37 Tate Street - Permit 2018-00064

I have completed my initial zoning review and I need more information before I can approve the permit application and move it forward in the review process.

A 1st Floor Plan
1/8"= 1'-0"

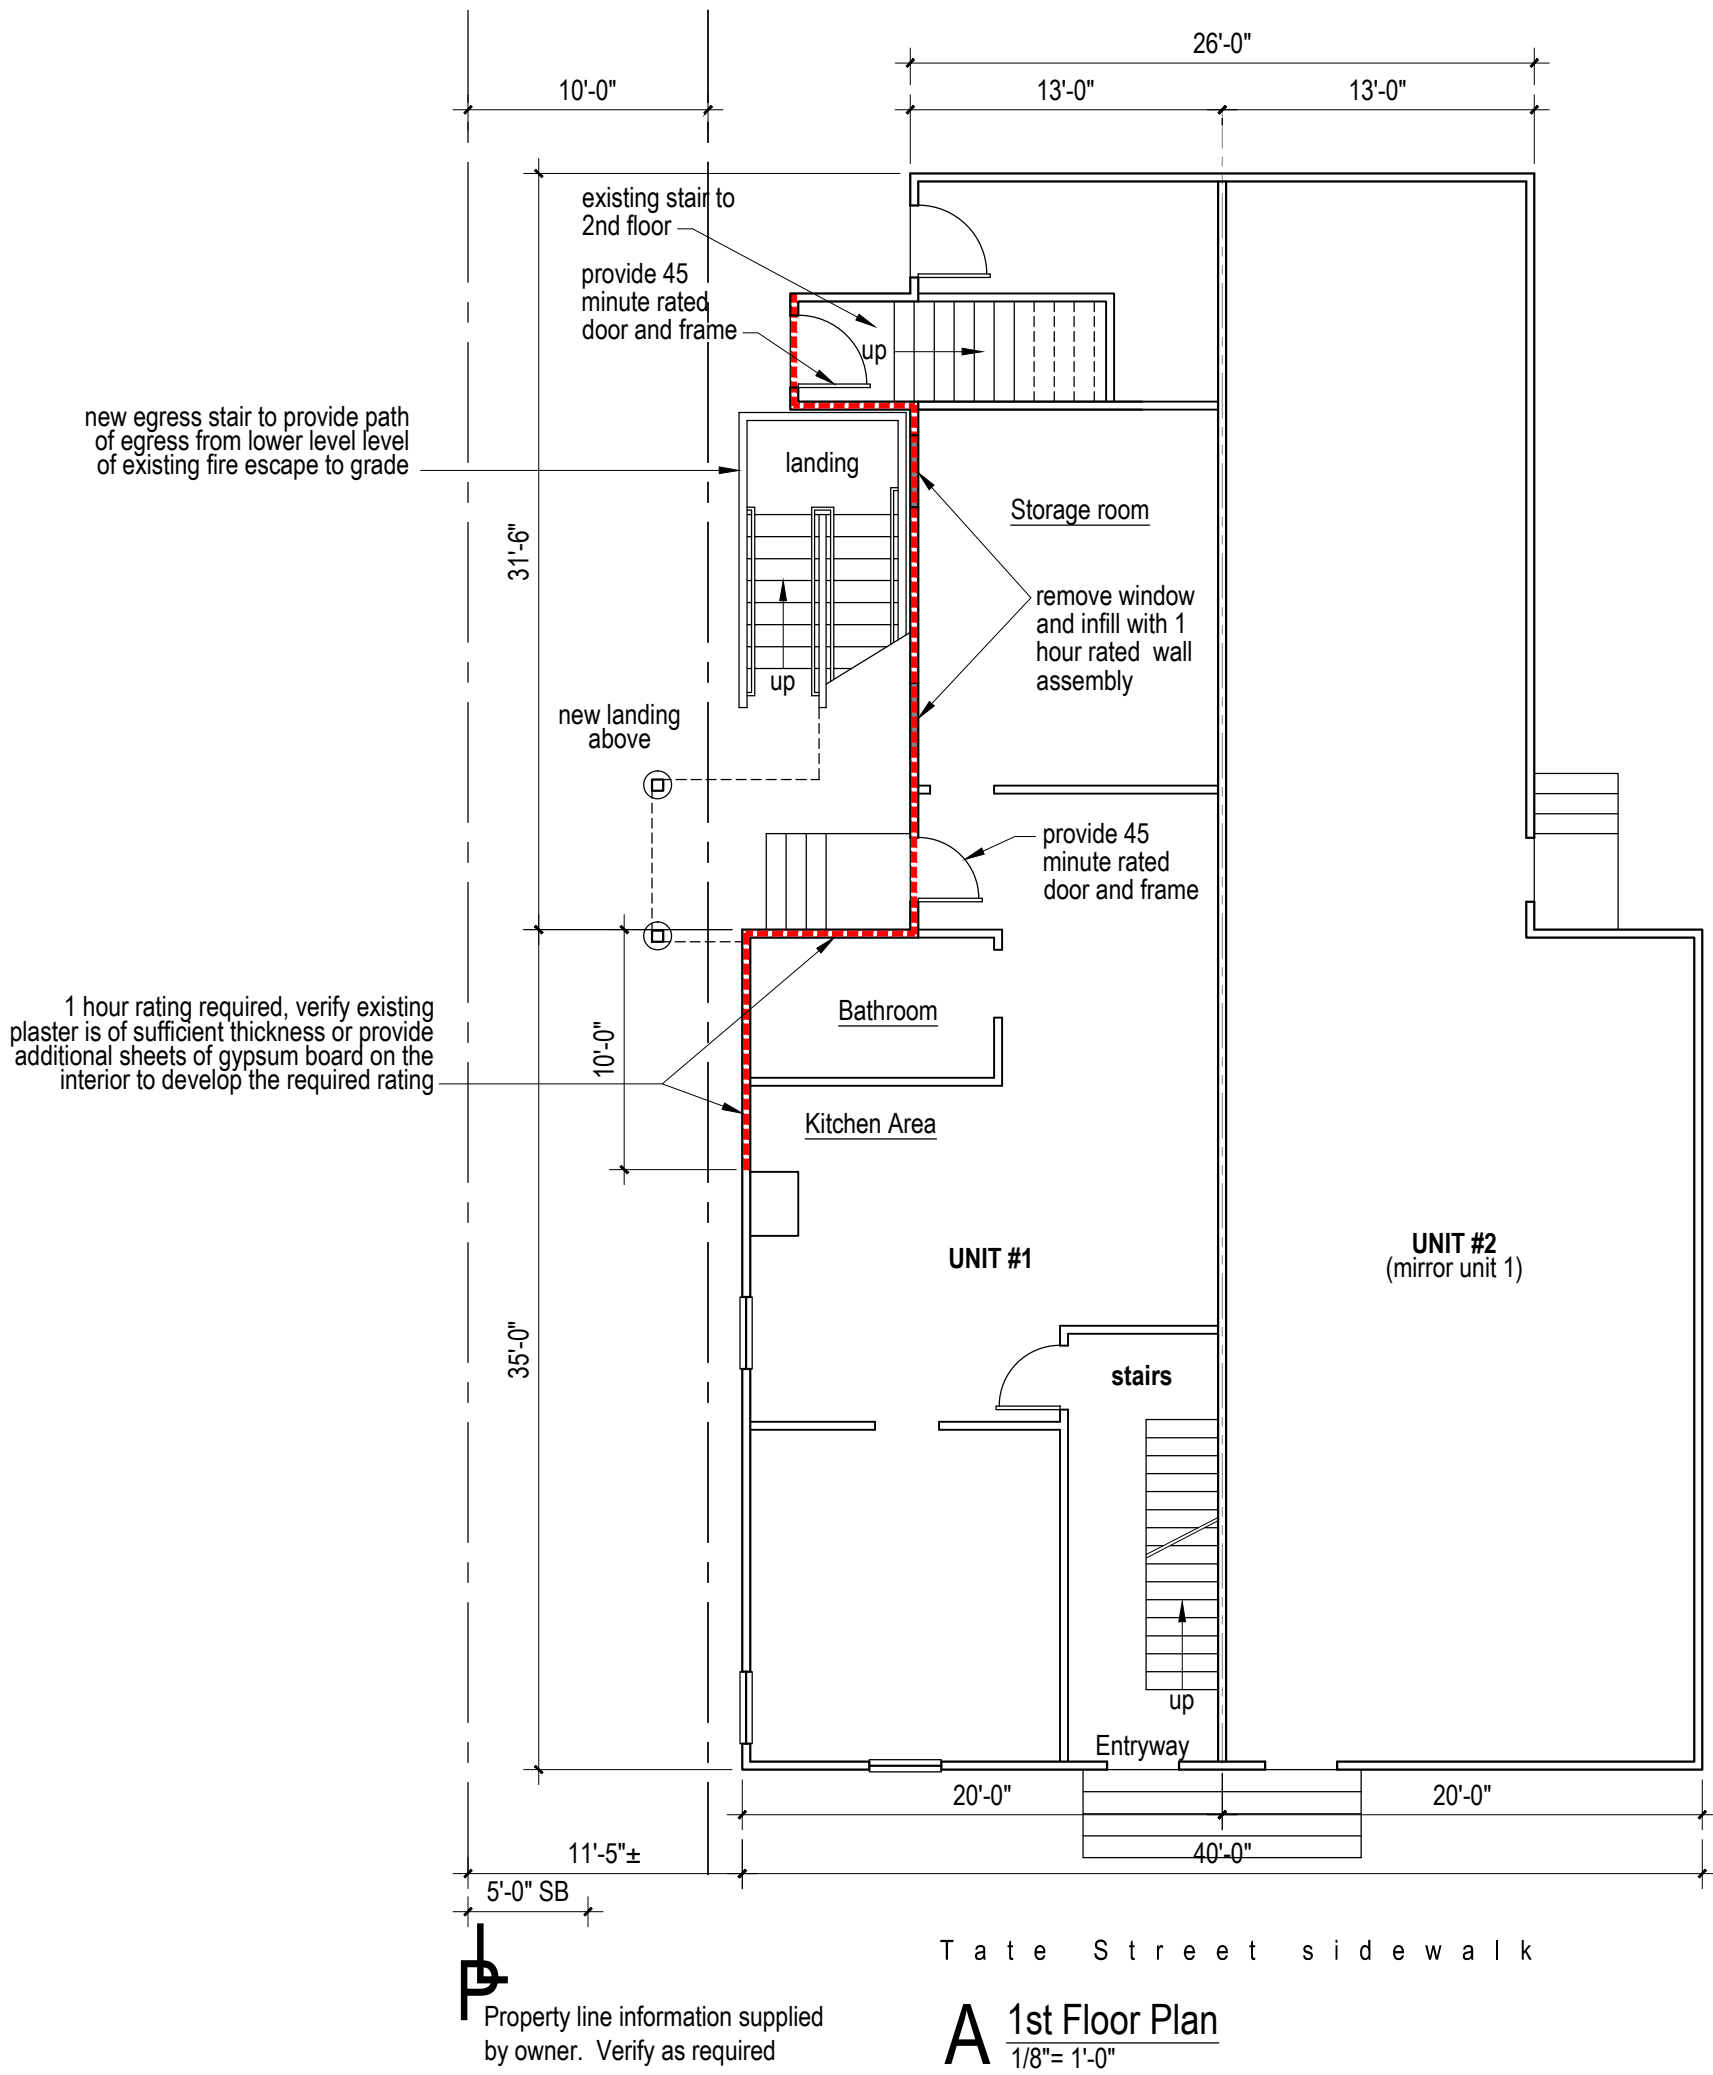
2. The project description on the application states, "Adding egress stairs to existing fire escape. Drywall in the storage room in the back". You seem to be adding a fire escape across the two story rear section of both 37 and 35 Tate Street. Regarding the dry wall, none of the plans show where the drywall is being added to the storage room. There appears to be storage at the rear of the first floor but this also seems to be part of the rear egress from the second floor.

B 2nd Floor Plan
1/8"= 1'-0"

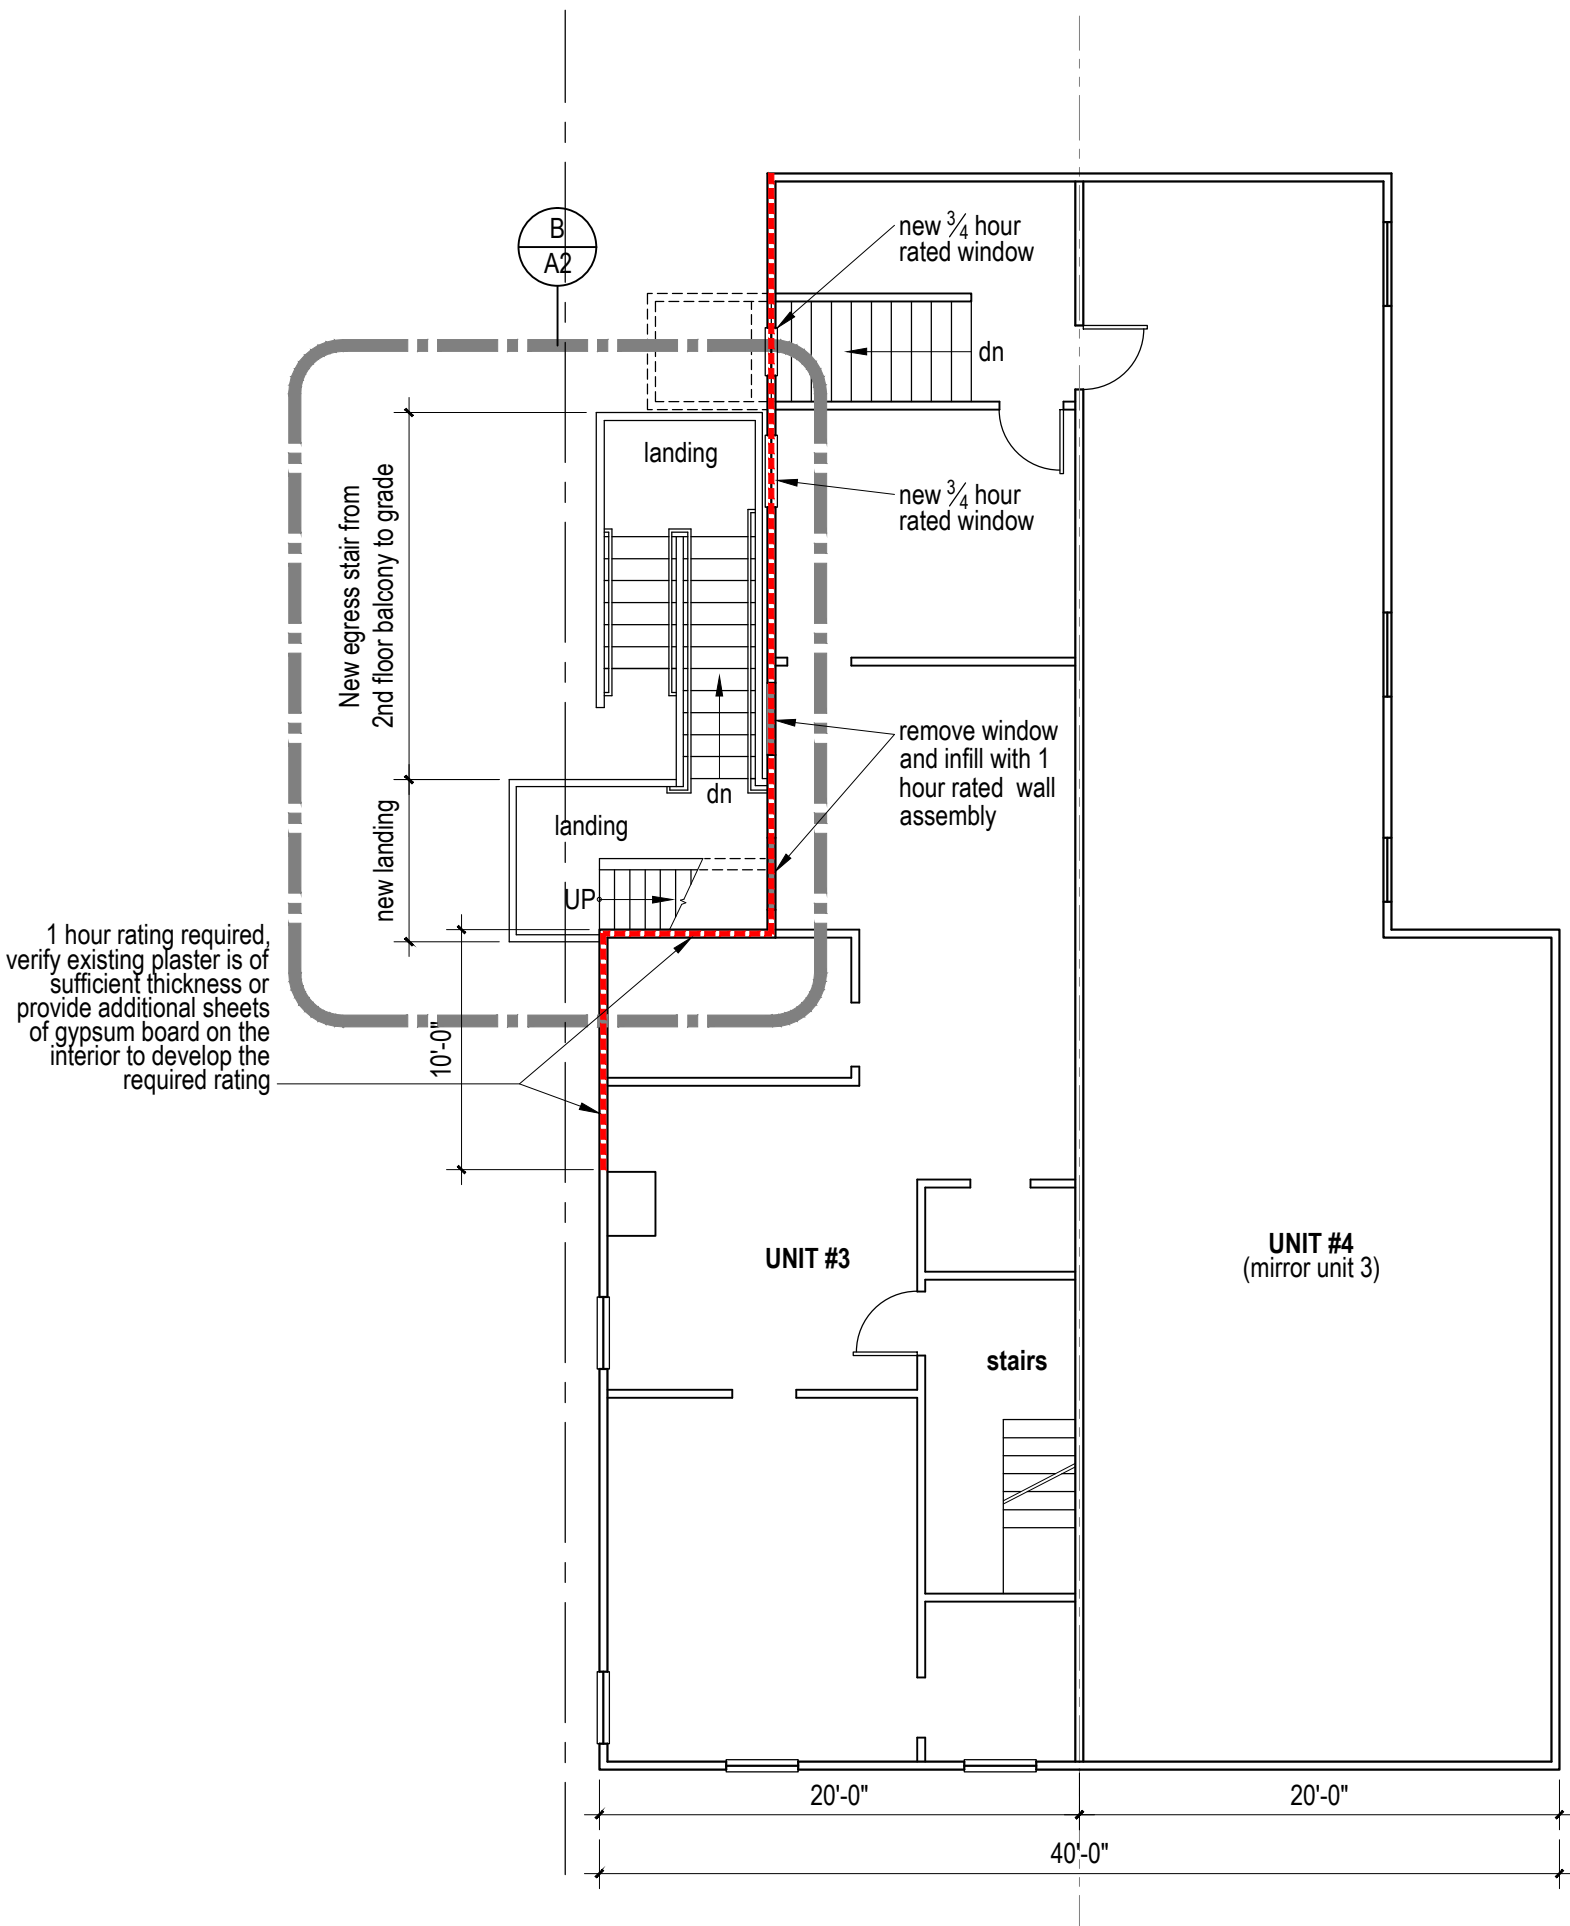
4. The plan labeled "egress 2" shows that the second floor apartment has two means of egress - a set of stairs in the front and a set of stairs in the rear. There is no need for a fire escape for egress from the second floor unit.

C 3rd Floor Plan
1/8"= 1'-0"

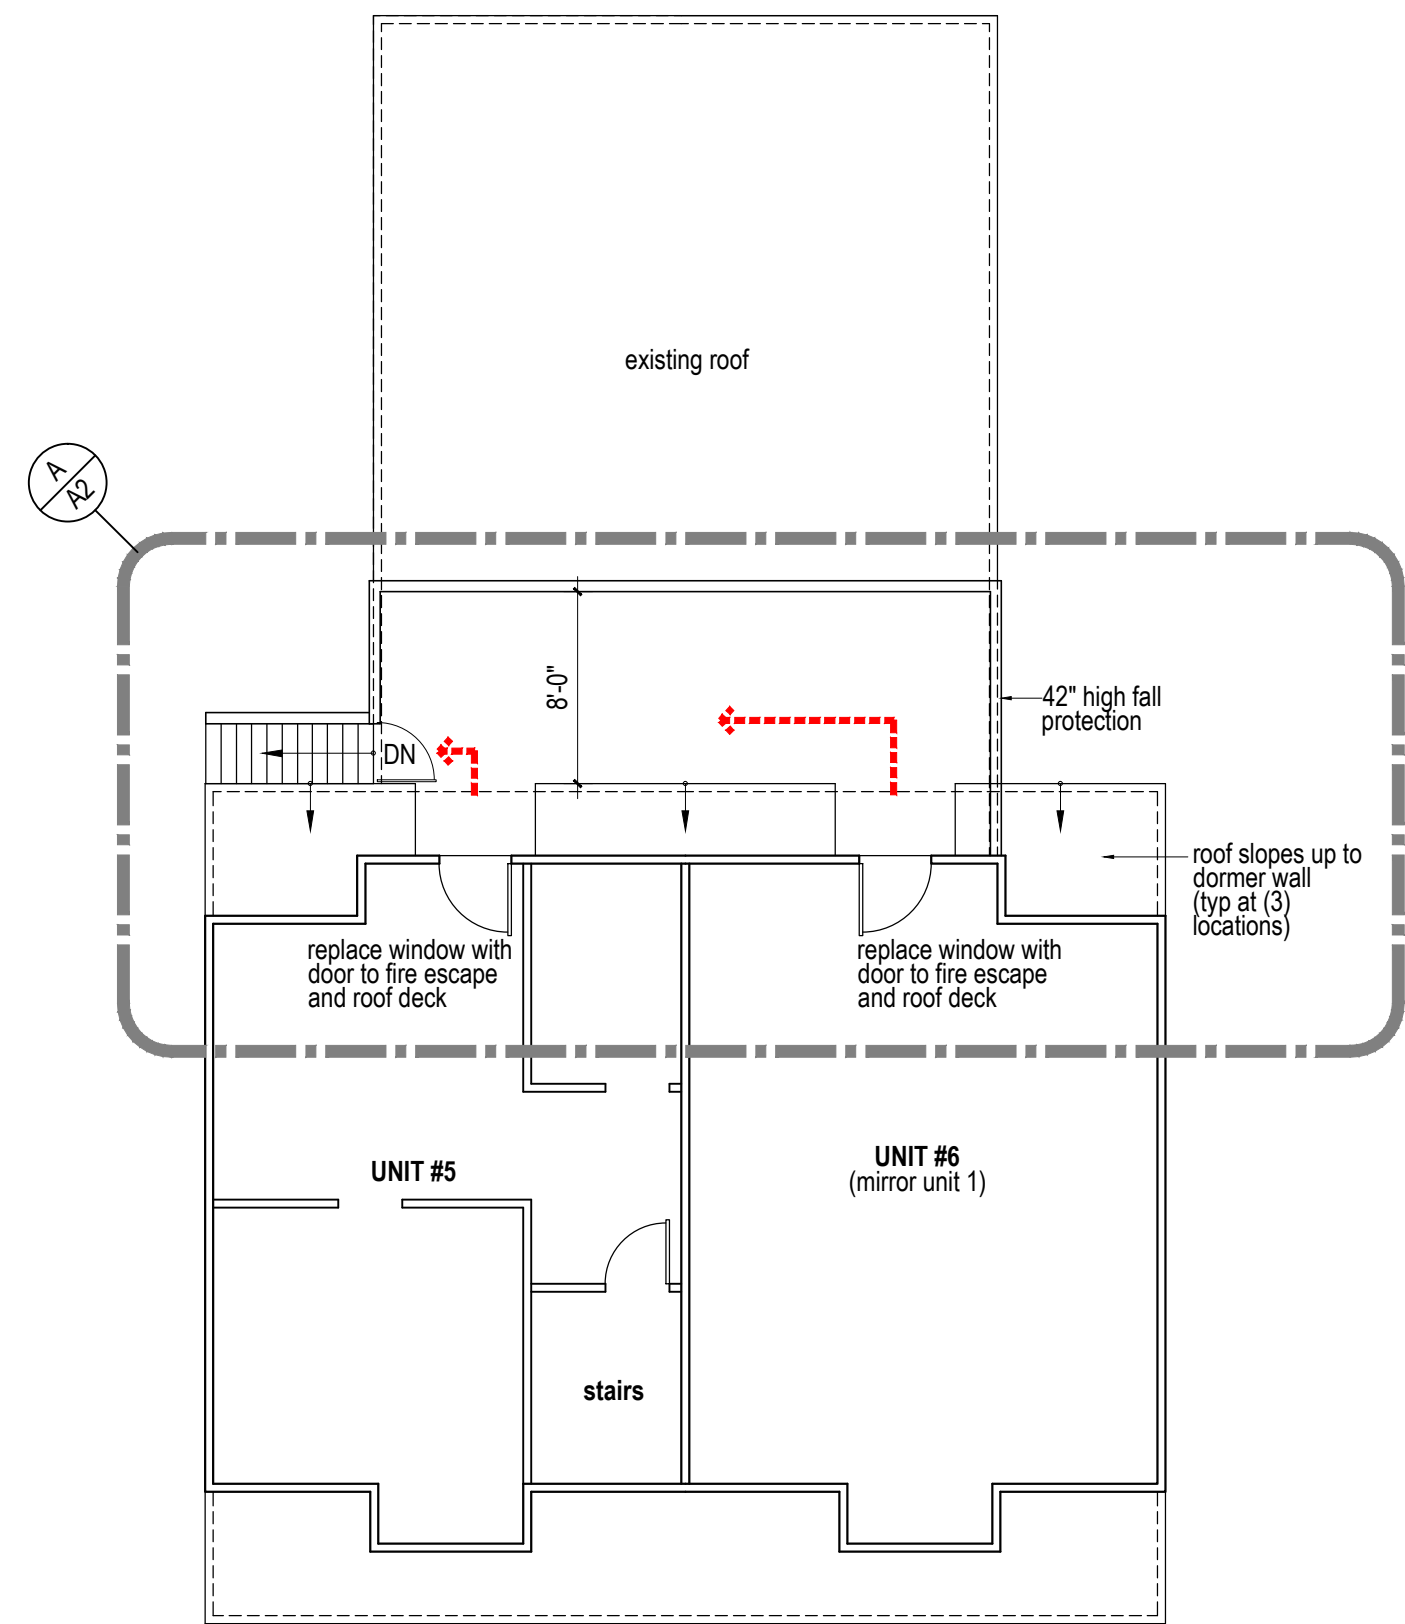
5. The plan labeled "egress 3" shows the third floor apartment. There is no interior stair shown to access this unit. You need to revise this plan to show the primary means of egress. It appears that the proposed fire escape is only required as a second means of egress for the third floor unit.
